Our Ref: BE/74/19/PL

Town & Country Planning Act 1990 (as amended)
Town and Country Planning (Development Management Procedure) (England) Order 2015
Application for Full Planning Permission

Development Construction of entrance door & ramp on east elevation
Location 218 Chichester Road North Bersted

EXISTING ELEVATION (EAST)
218 CHICHESTER RD. BERSHED
Scale 1:100

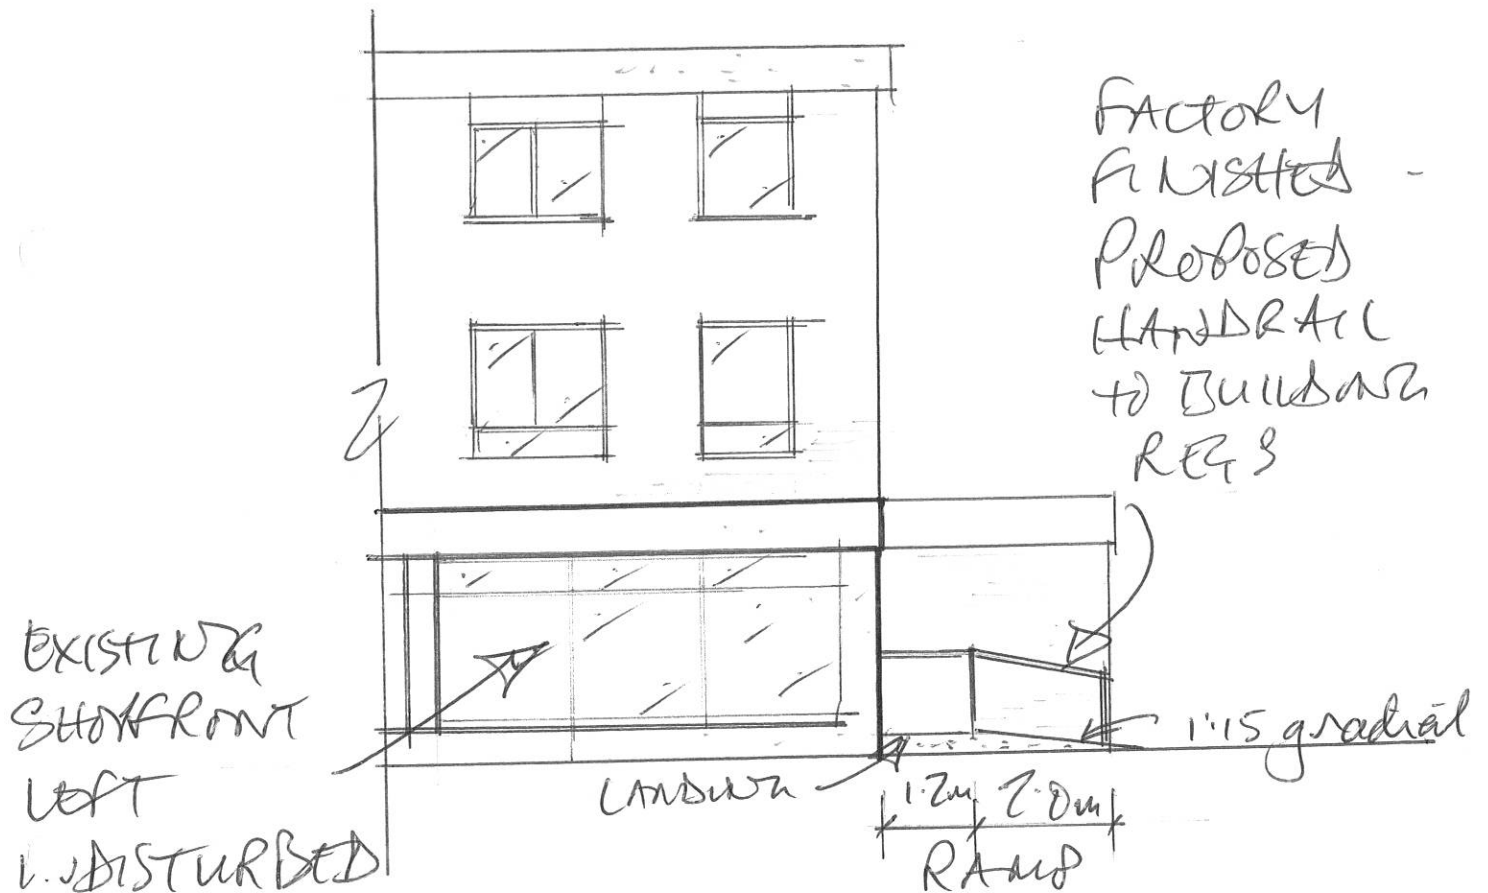
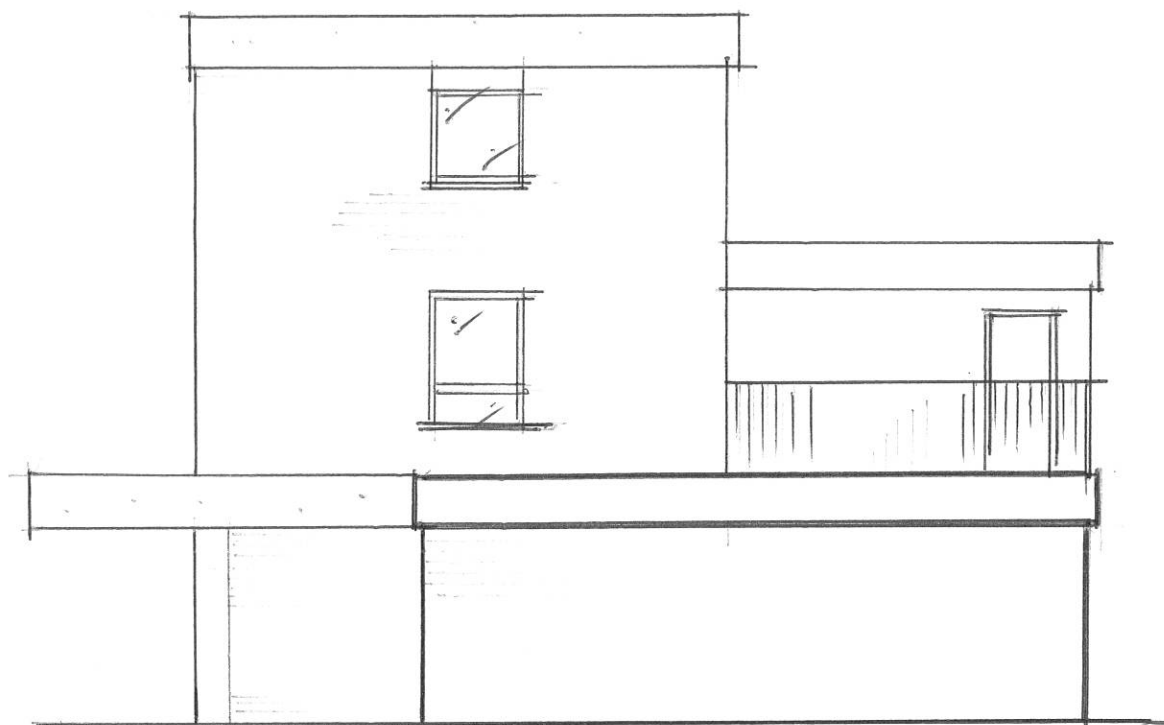
The elevations submitted are still not complete. Please submit 1 electronic or 3 paper copies of amended elevations to scale clearly showing the existing and proposed elevations and the ramp gradient/details.
